Current Zoning: R-3LWPA (single family residential, Lake Wylie Protected Area)
Proposed Zoning: R-8MF(CD)LWPA (multi-family residential, conditional, Lake Wylie Protected Area)

Approximately 11.23 acres located at the southeast intersection of Oakdale Road and Mt. Holly-Huntersville Road, north of Interstate 485

The petition proposes to redevelop 4 large single family lots with up to 88 single family attached units as a second phase of development approved for the adjacent site to the east in northwest Charlotte.

REZONING PETITION #2022-170
SCHEMATIC SITE PLAN

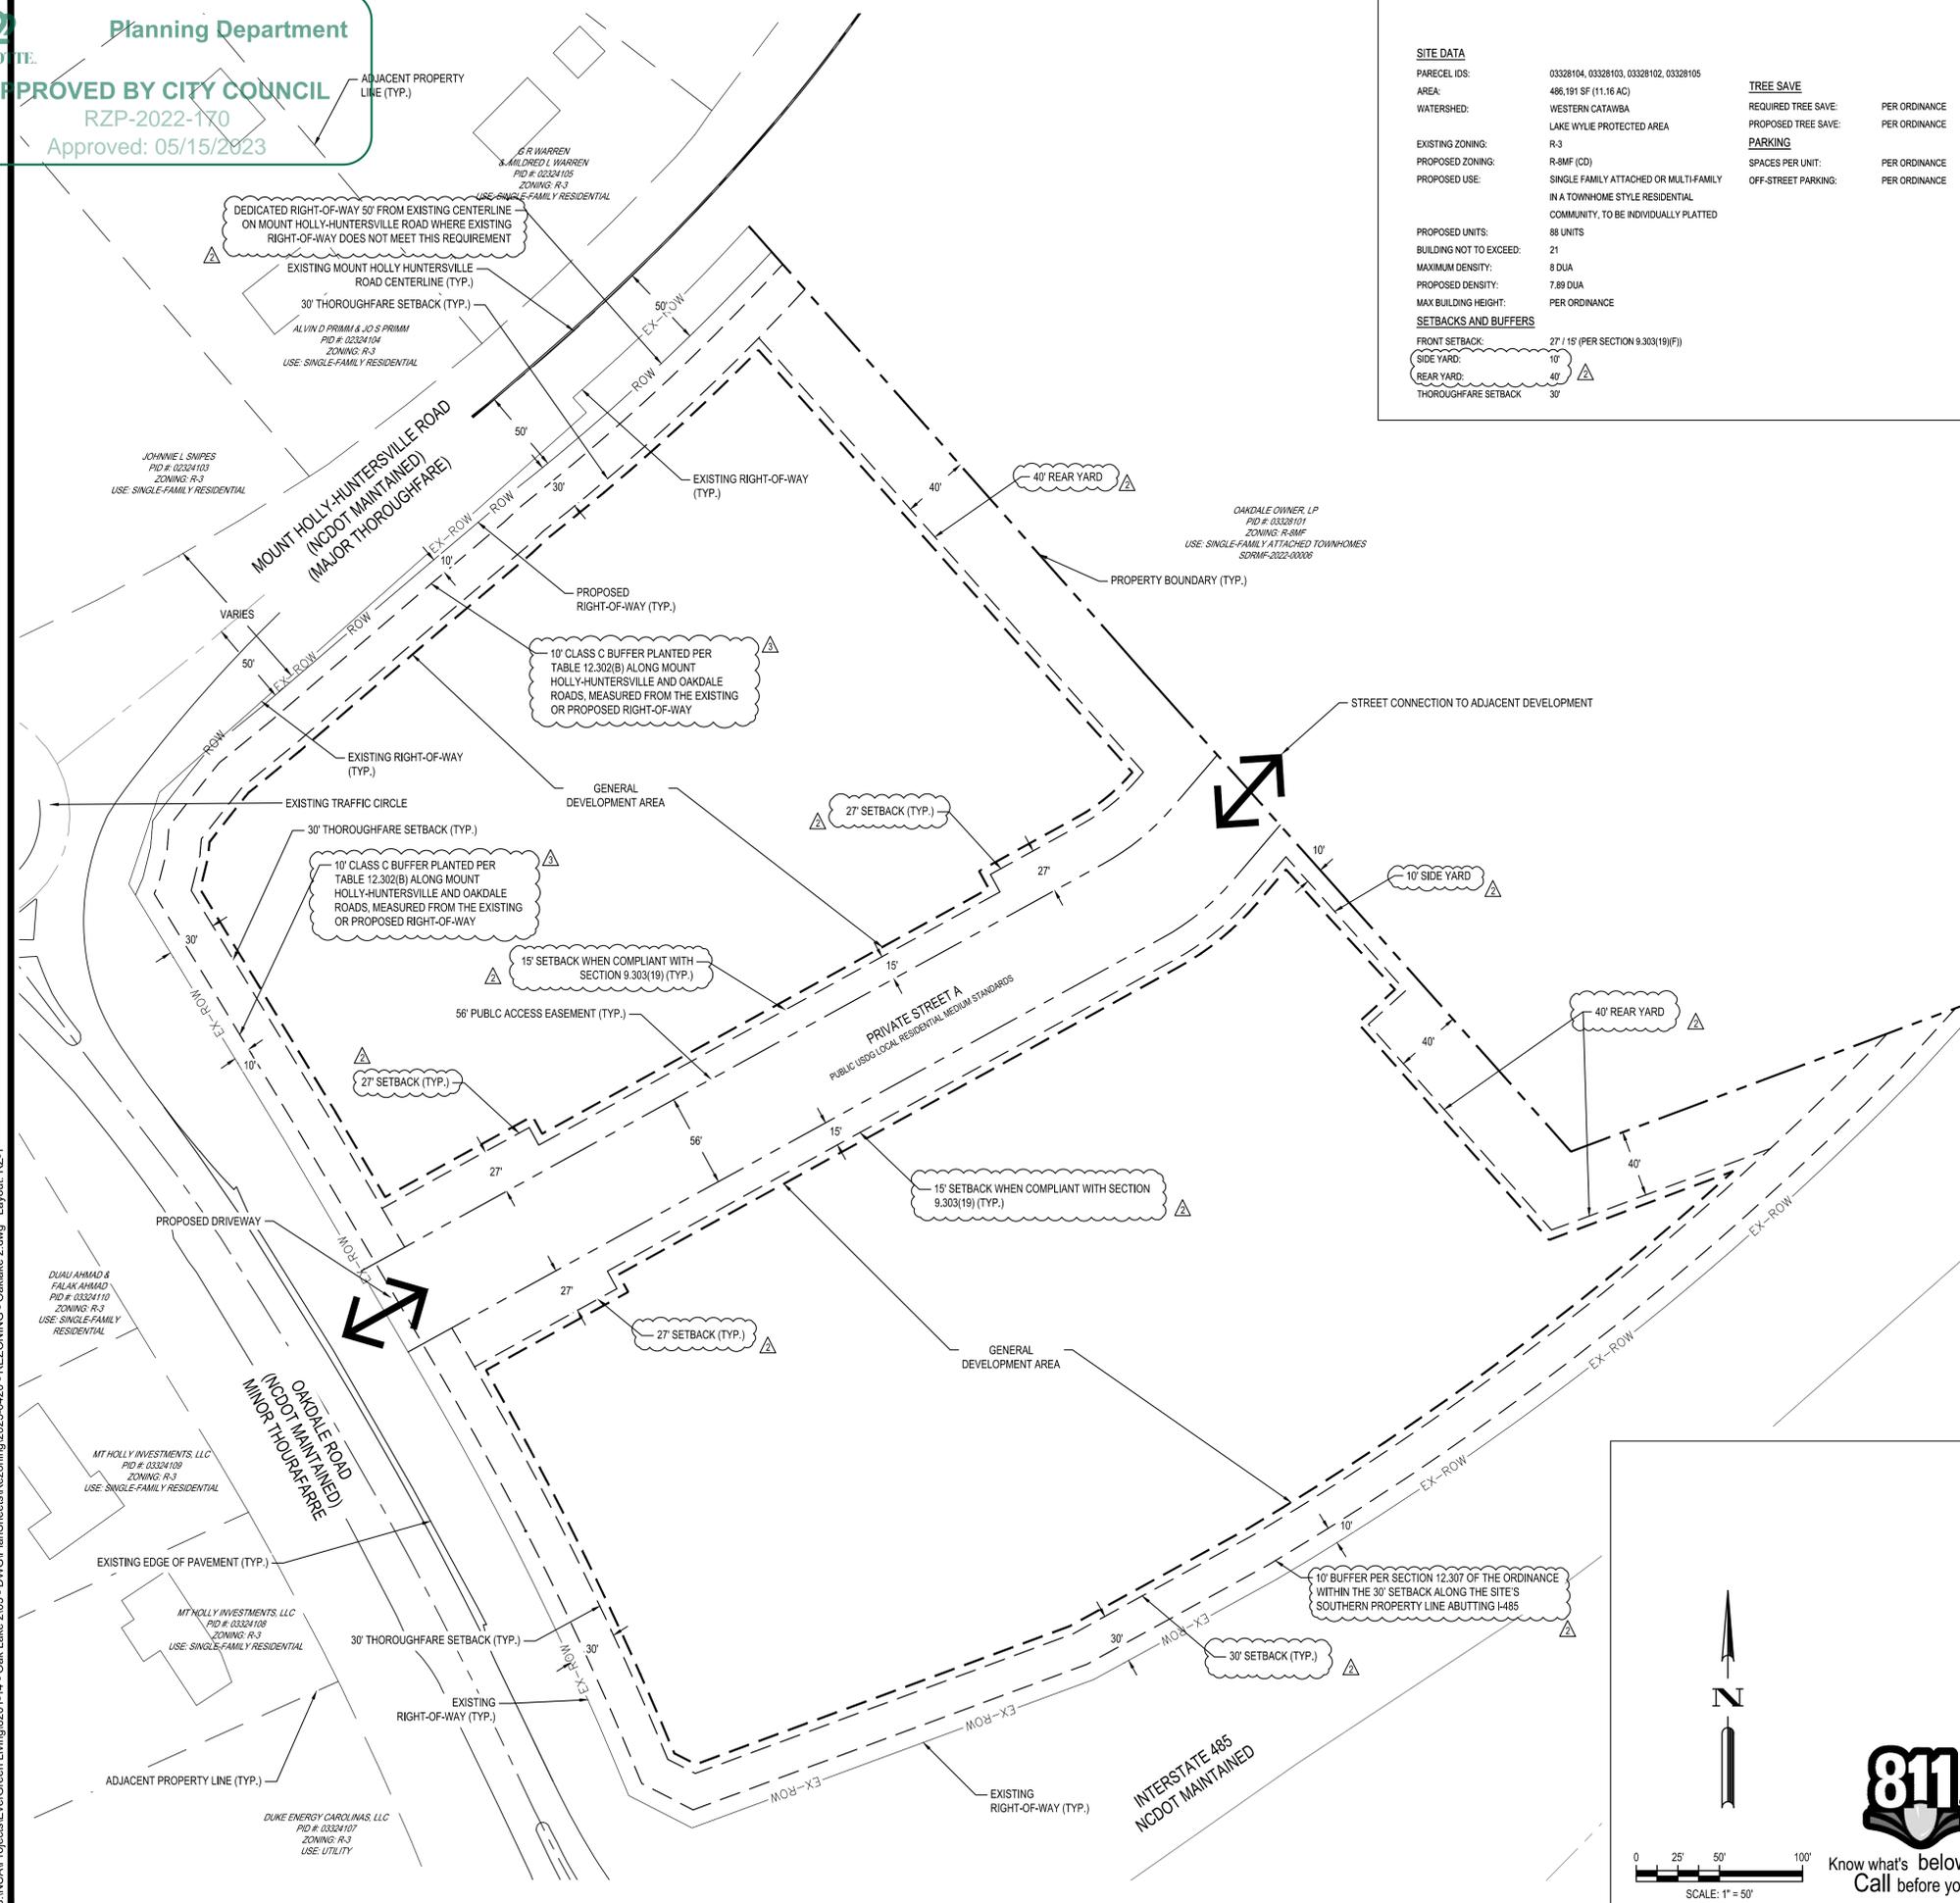
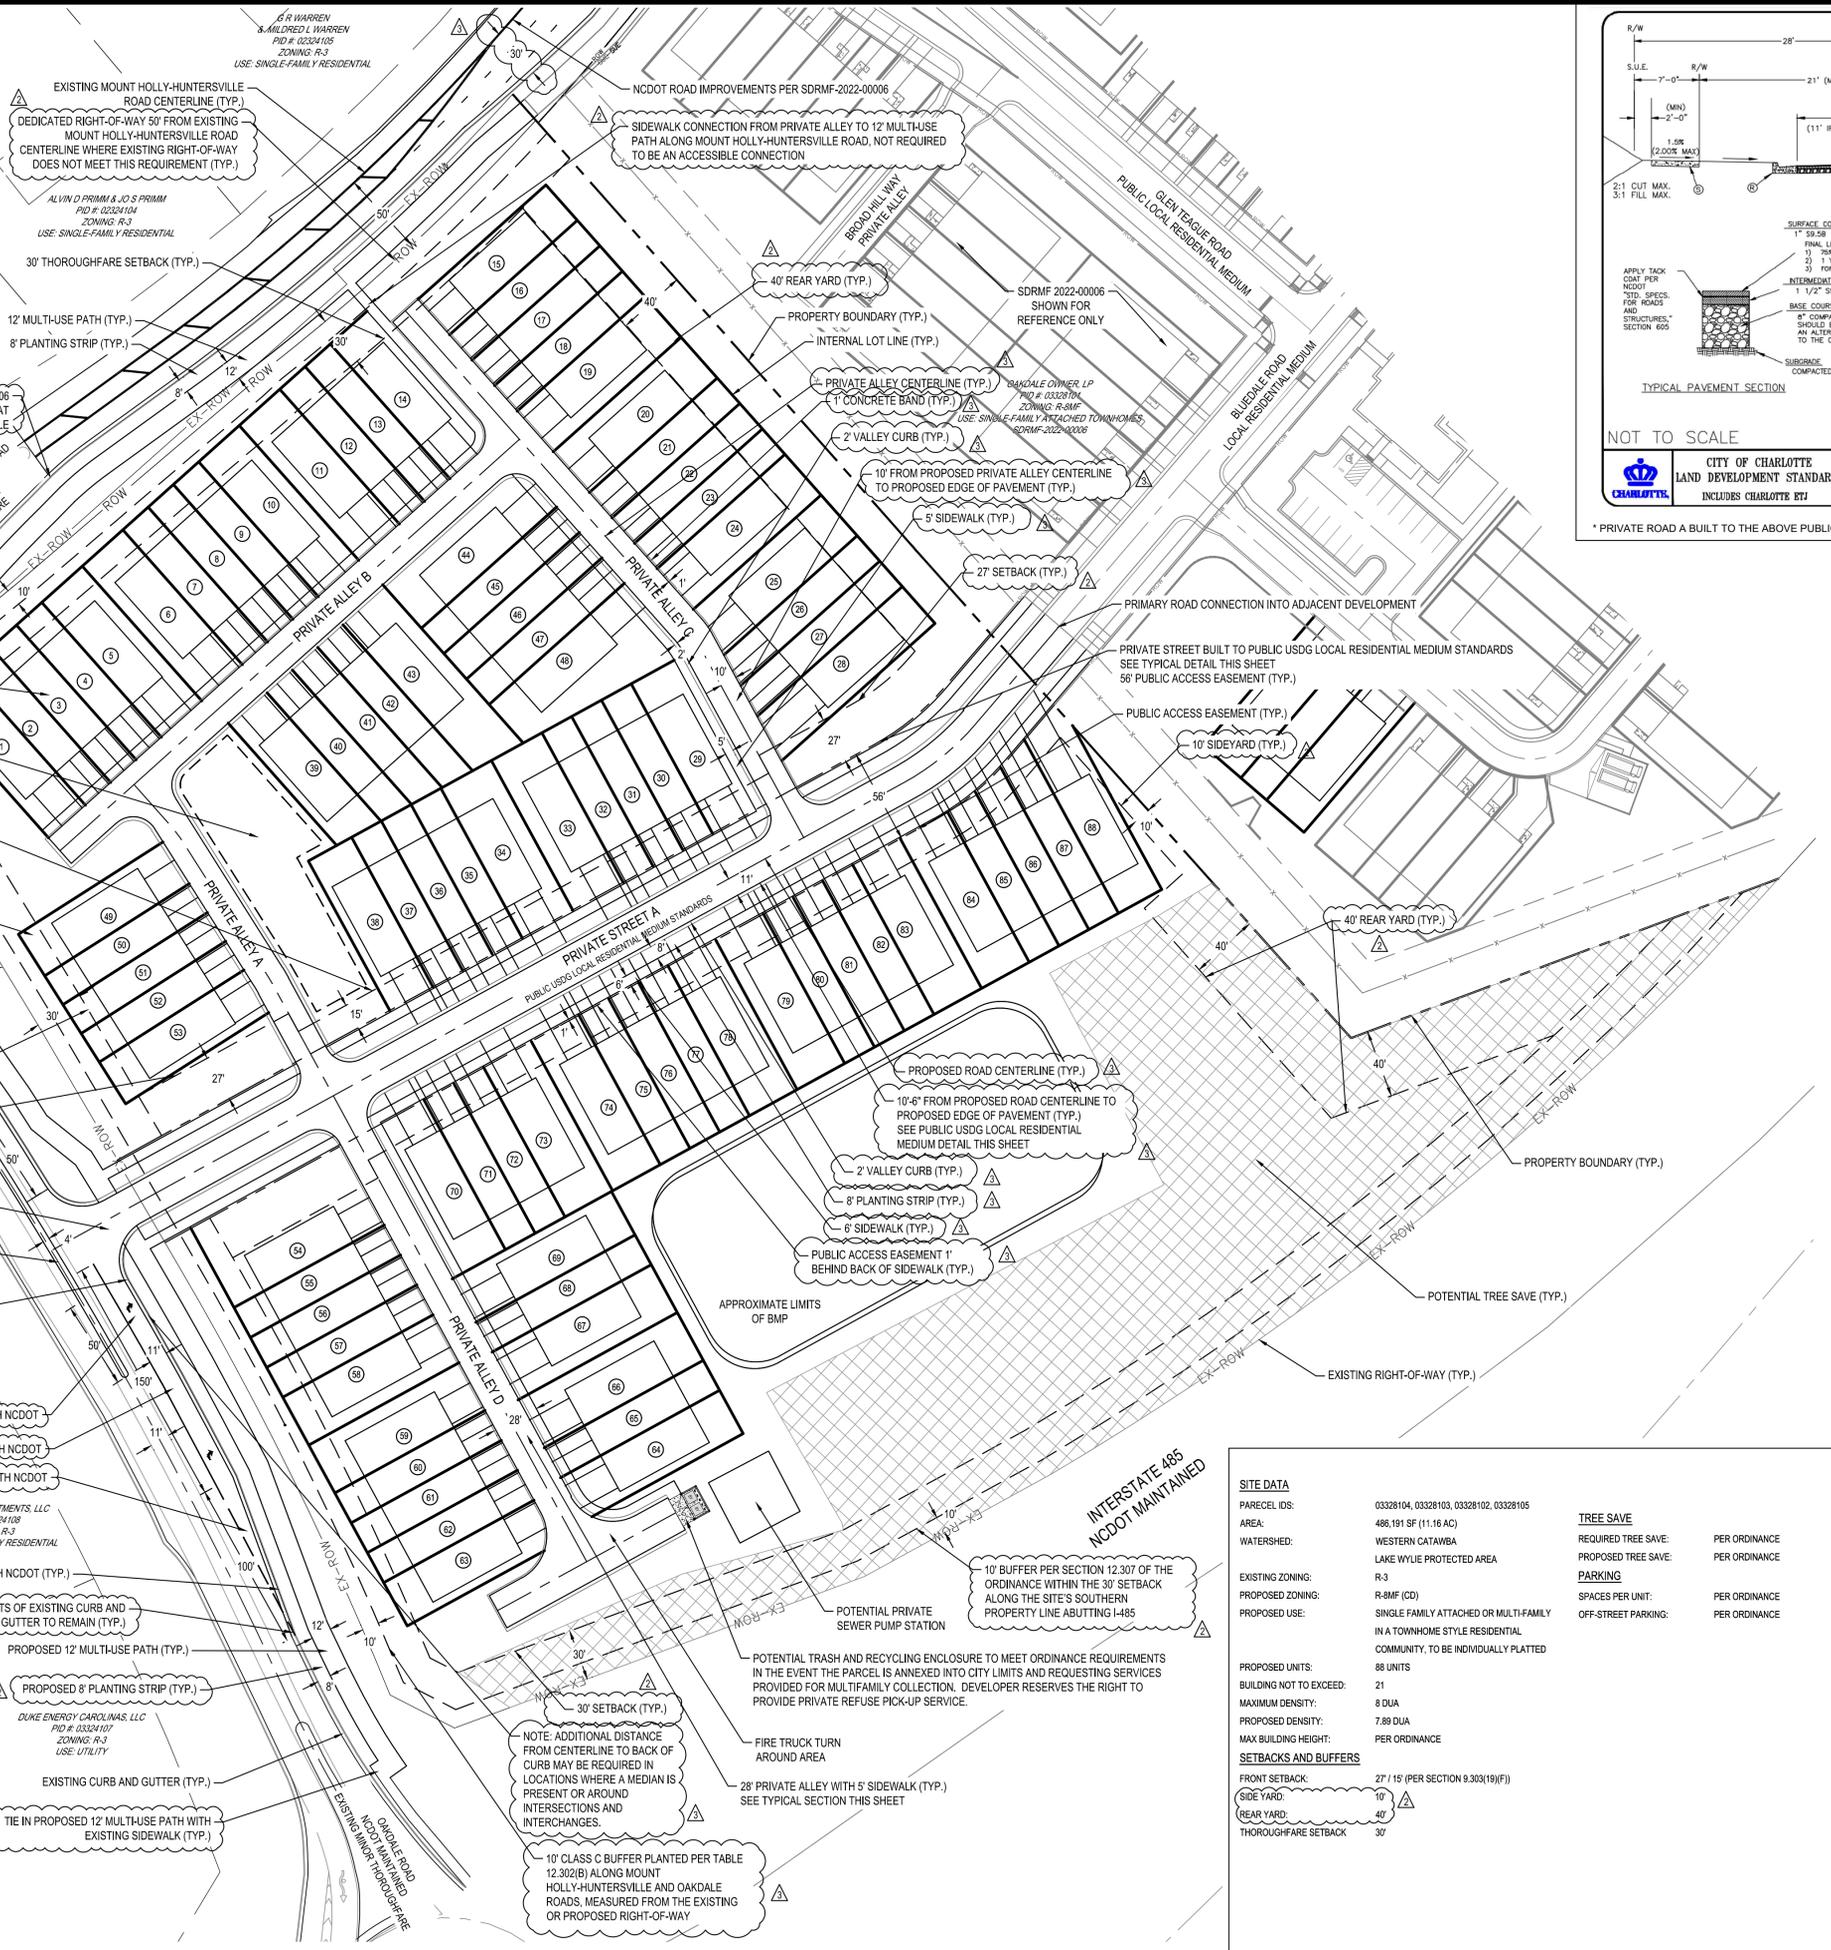
1. ~~Add provision for landscaping including trees and shrubs along the frontages of Mt Holly Huntersville Rd and Oakdale Rd.~~ Addressed
2. ~~Revise Architectural Standard note F. related to visual impact of garage doors by making Porch/stoops a part of every unit and its own individual note. And remove iv. related to windows above or beside the garage door.~~ Addressed, removed the note related to porches and stoops and separated the other options.
3. ~~Remove strike throughs from development standards on the site plan.~~ Addressed
4. ~~Commit to a total minimum area for the amenity area(s).~~ Addressed

5. ~~Label and dimension the curb and gutter from the centerline for each road on the site plan.~~ Addressed
6. ~~Location of curb and gutter along Mt. Holly Huntersville Rd. to be moved 30 ft from roadway centerline to accommodate Charlotte Streets Map with a section of 4+ Avenue and shared use path.~~ Addressed

7. ~~Label and dimension internal street infrastructure including curb line, sidewalks, plantings strips and right-of-way.~~ Addressed
8. ~~Add a conditional note specifying "A Right of Way Encroachment Agreement is required for the installation of any non-standard item(s) (irrigation systems, decorative concrete pavement, brick pavers, etc.) within a proposed/existing city-maintained street right-of-way by a private individual, group, business, or homeowner's/business association. An encroachment agreement must be approved by CDOT prior to construction/installation. Contact CDOT for additional information concerning cost, submittal, and liability insurance coverage requirements."~~ Addressed

11. ~~Remove driveways from CDOT 50'x50' sight triangles areas connecting to Street A.~~ Addressed
